Online Comment

Application H16-0526-25
Location MONKS HOUSE BOURNE ROAD SPALDING PE11 1JR
Proposal Conversion of loft space into additional bedrooms, internal alterations, provision of conservation rooflights to west elevation and complete re-roofing and reinstatement of historic windows

Name Spalding & District Civic Society
Address 36 Park Avenue Spalding Lincs PE11 1QX

Date Submitted 21-06-25
For/Against Objections

PLANNING			
PROJECT TITLE:		MONK'S HOUSE	
DRAWING TITLE:		GROUND FLOOR PLANS	
DRAWING NO:	REVISION:	PAGE SIZE:	SCALE:
2548-PP01	A	A3	1:100

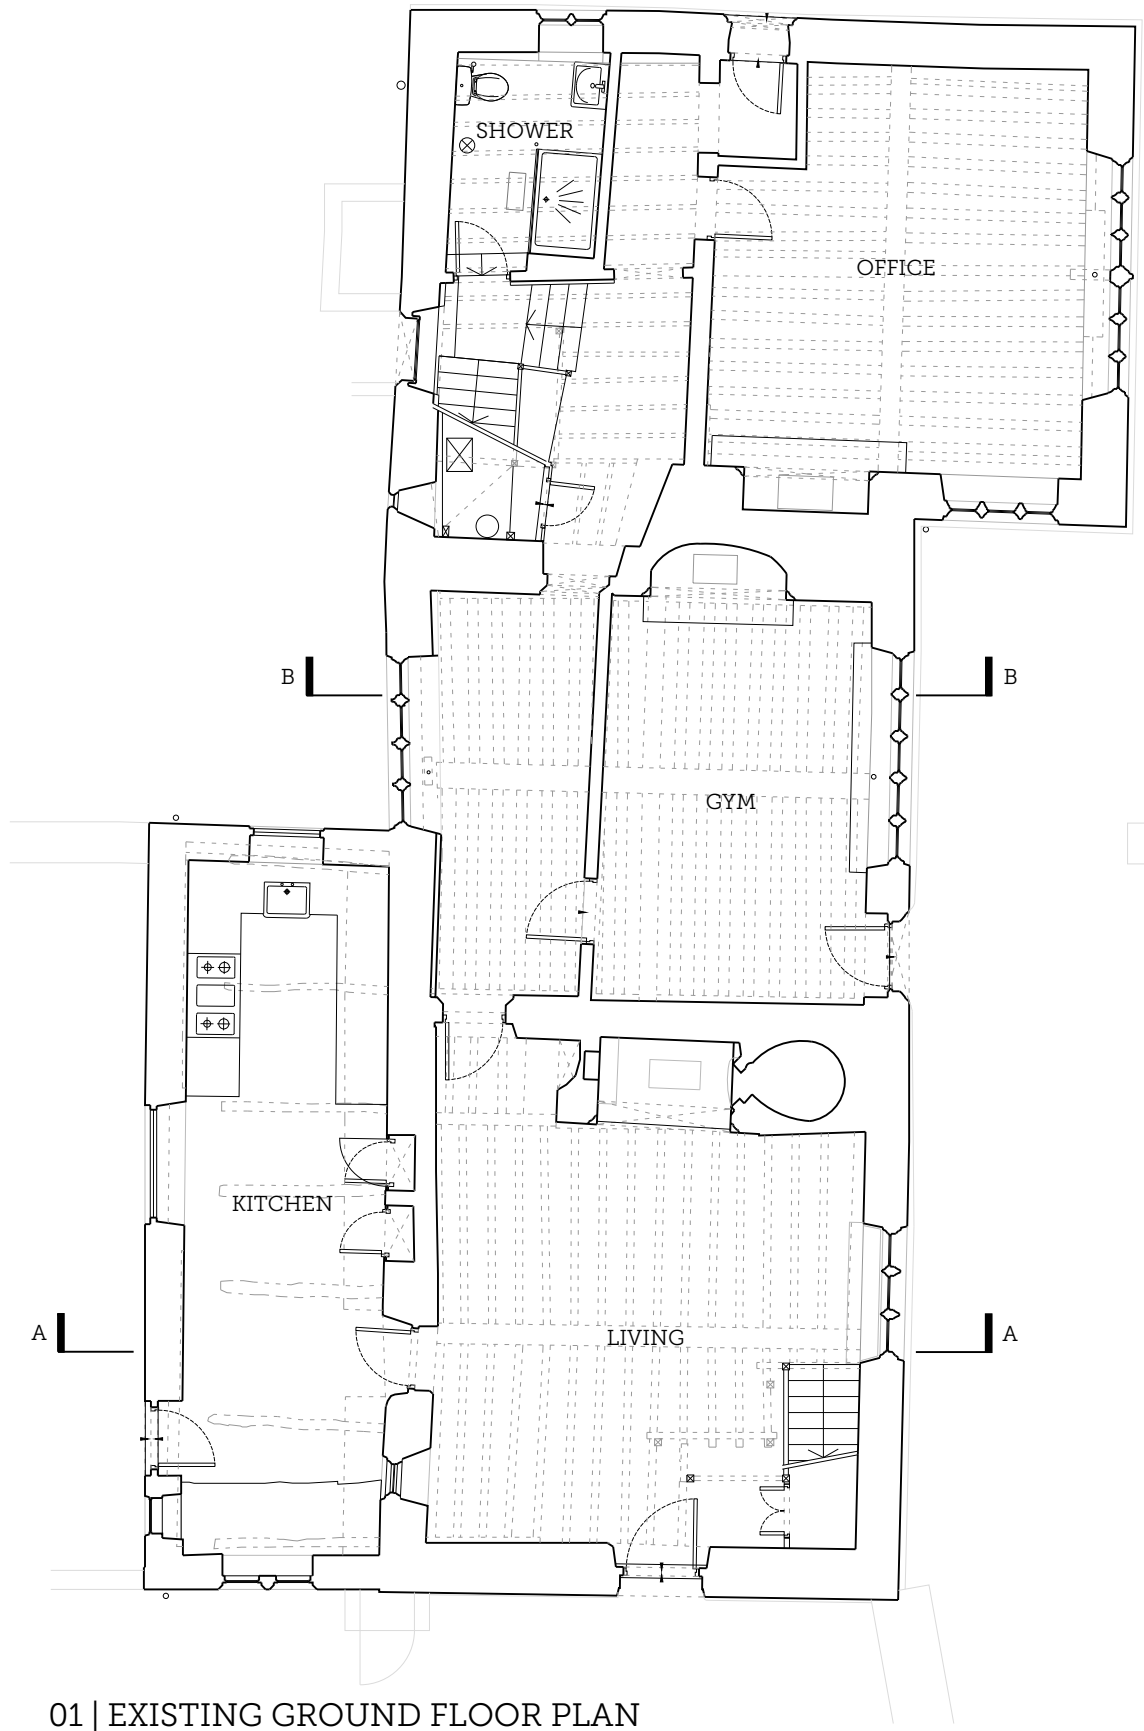
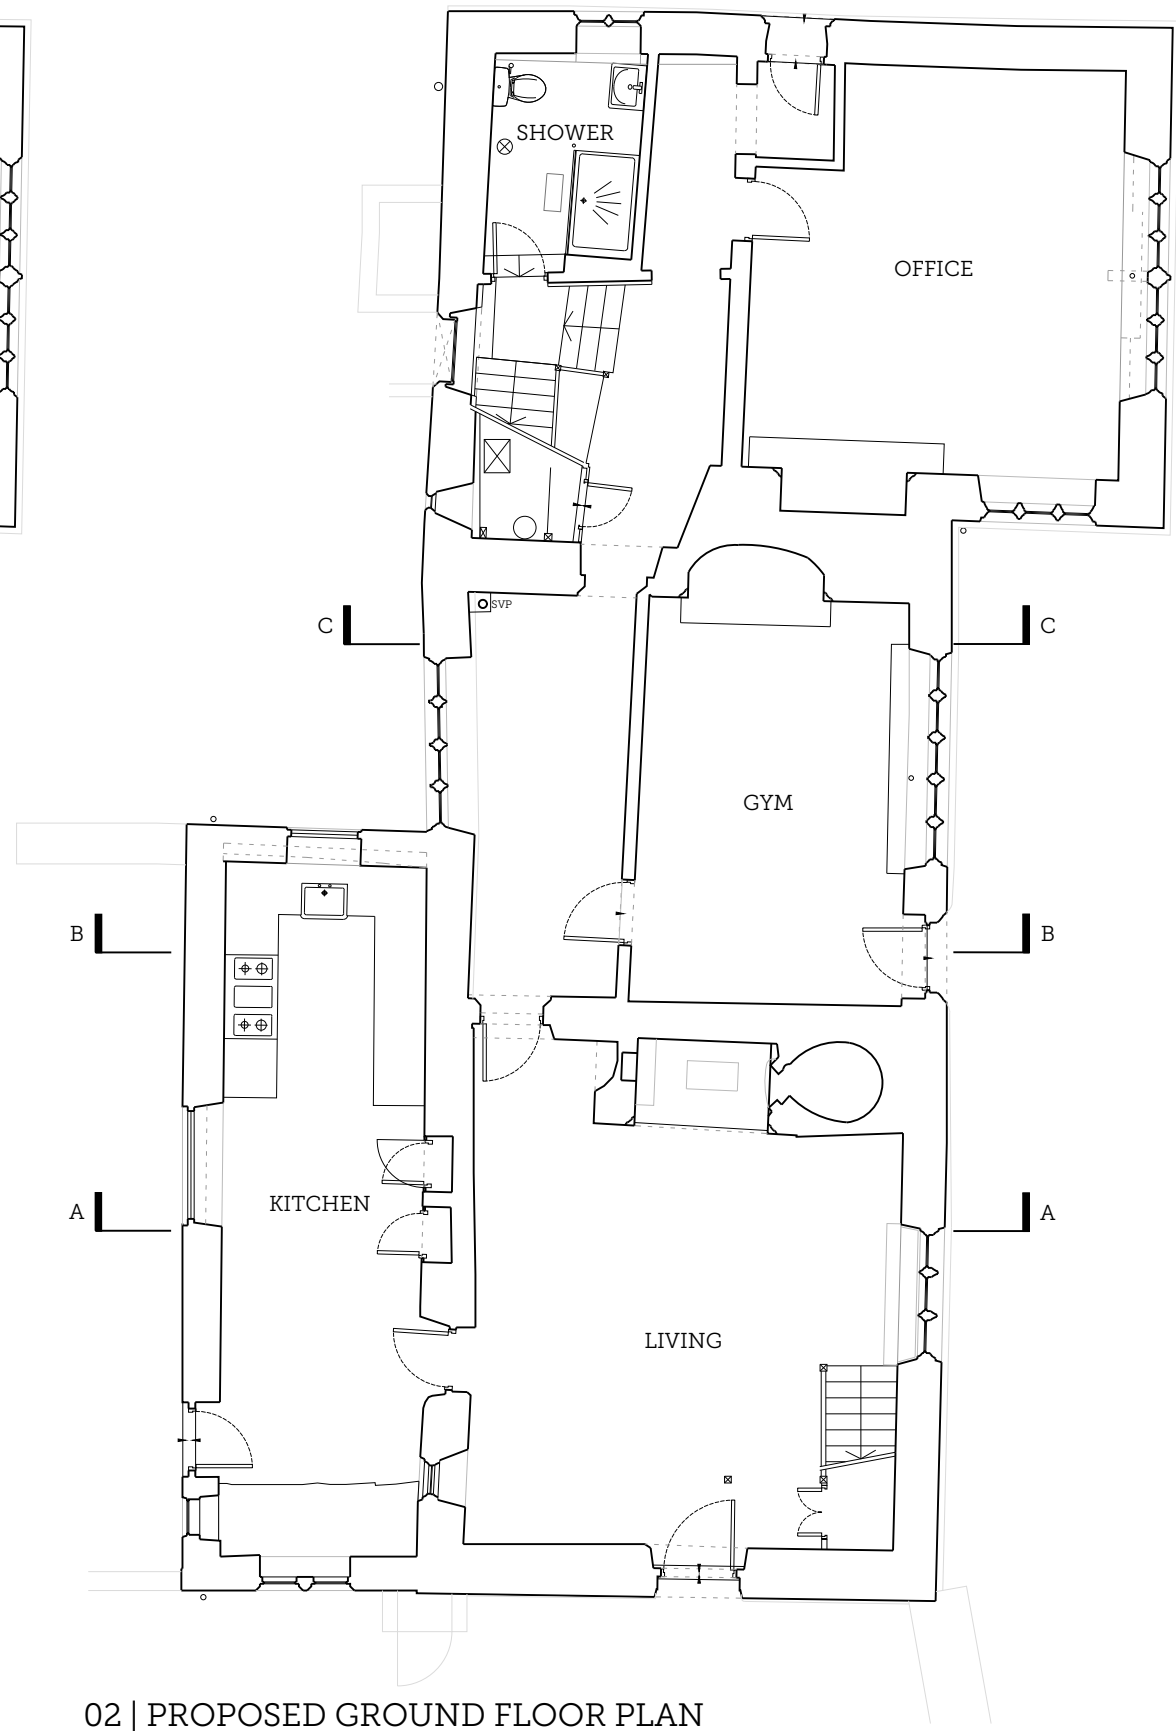
The proposal also seeks to replace a window at the ground floor west elevation. No information is provided about the existing window, its condition, reason for replacement, or the proposed replacement. Without sharing this detail, the window replacement could cause harm to the significance of the listed building."

It is also recommended that further detail is provided about works to install the new staircase(es), the ground floor window replacement, and the associated impacts on historic fabric."

PLANNING			
PROJECT TITLE:		MONK'S HOUSE	
DRAWING TITLE:		FIRST FLOOR PLANS	
DRAWING NO:	REVISION:	PAGE SIZE:	SCALE:
2548-PP02	A	A3	1:100

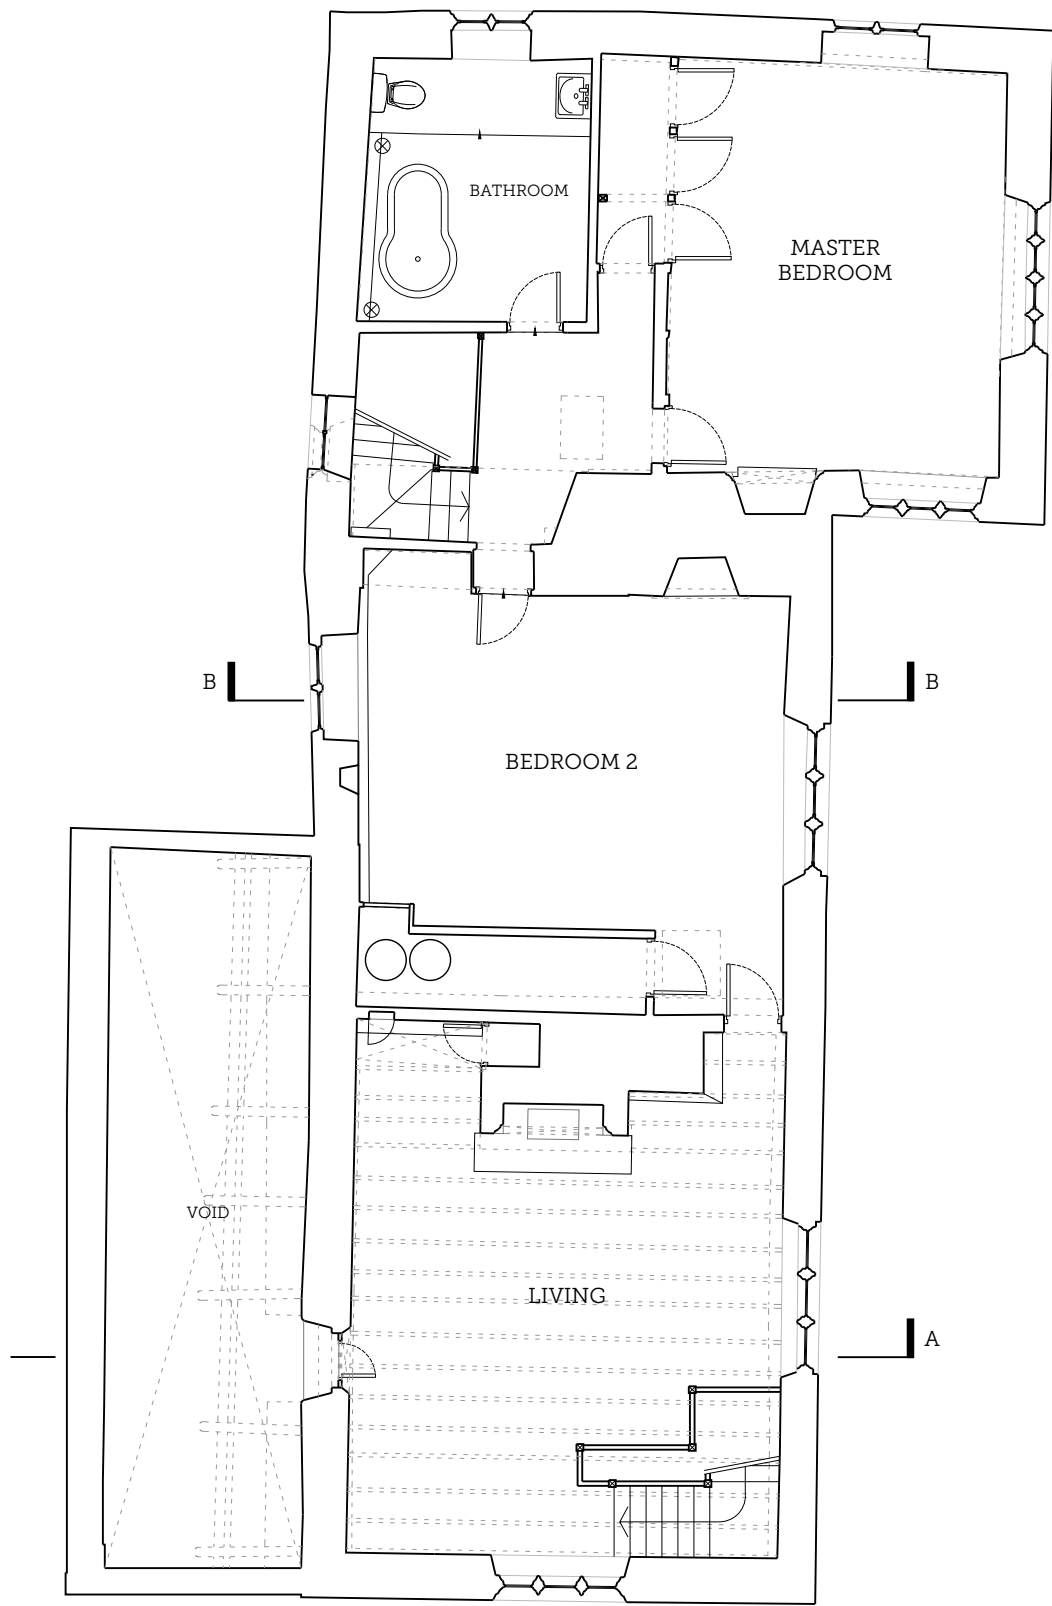
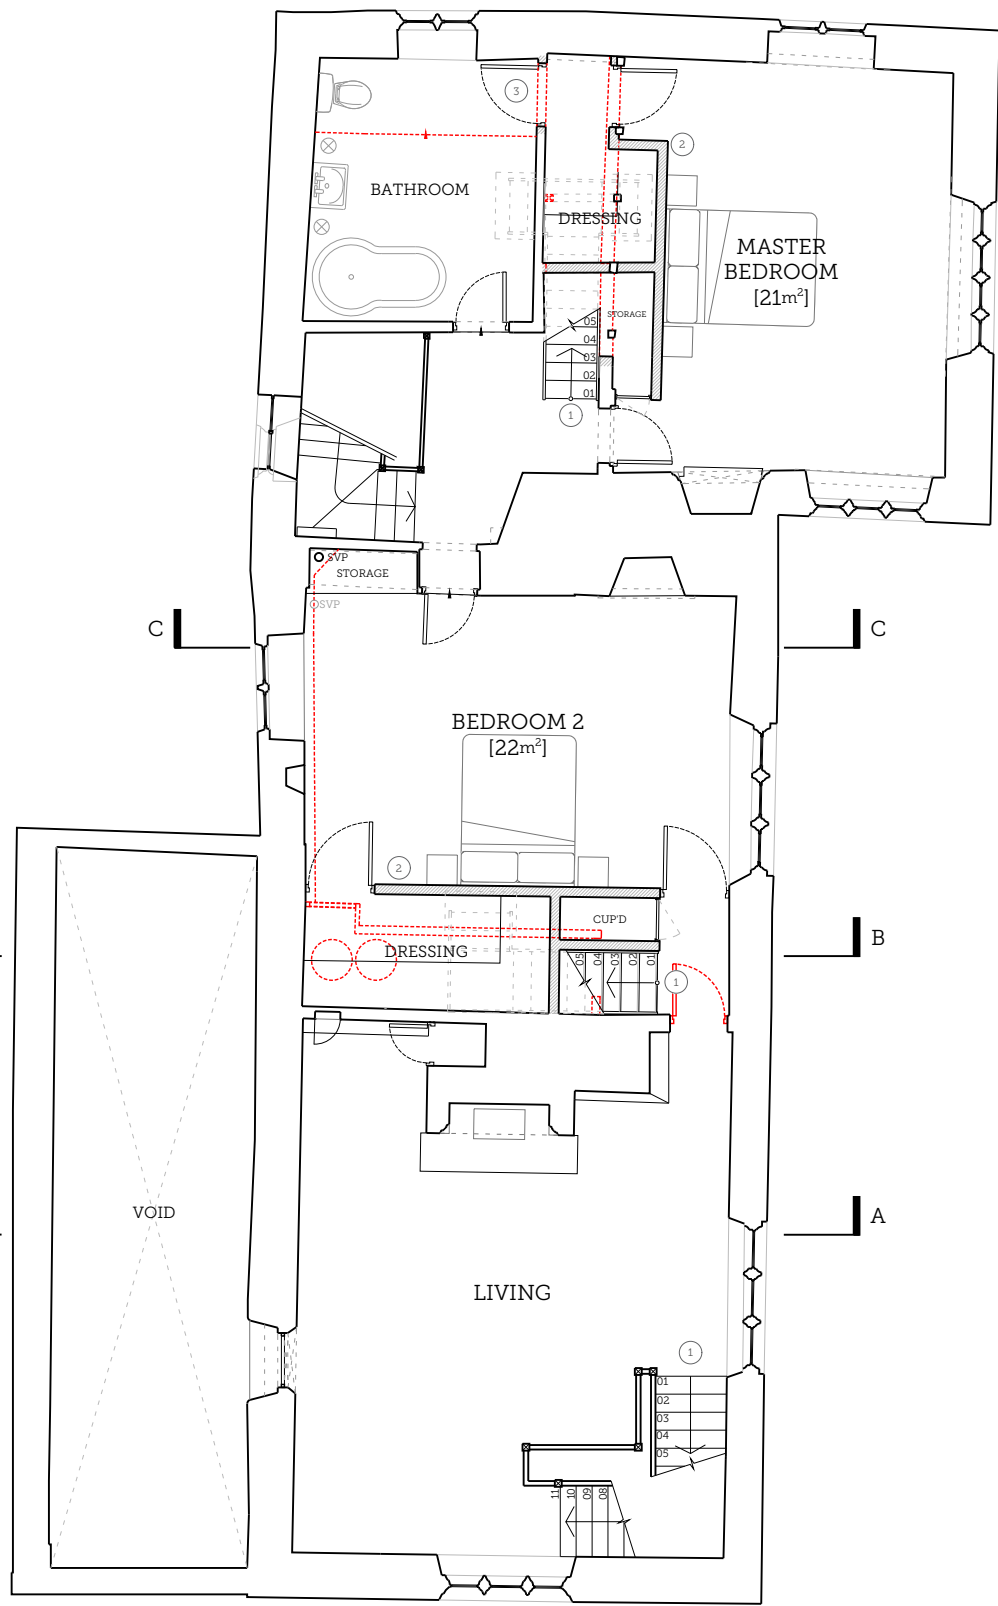
The application also seeks to install two new staircases at first floor to provide loft access. The Heritage Statement states that 'the proposed adaptions to the first floor are relatively simple with seemingly no loss of historic fabric'. However, no details of the proposed staircases or their impact on historic fabric has been provided. Without adequate detail about this element of the proposal it has the potential to cause harm to the significance of the building.

"We encourage the consideration of other options instead of the staircase such as interconnecting the loft spaces if possible, alternative staircase locations, opening up just one part of the loft, or reconfiguring the layout at ground / first floors to allow for the desired further bedroom accommodation there instead of in the loft.
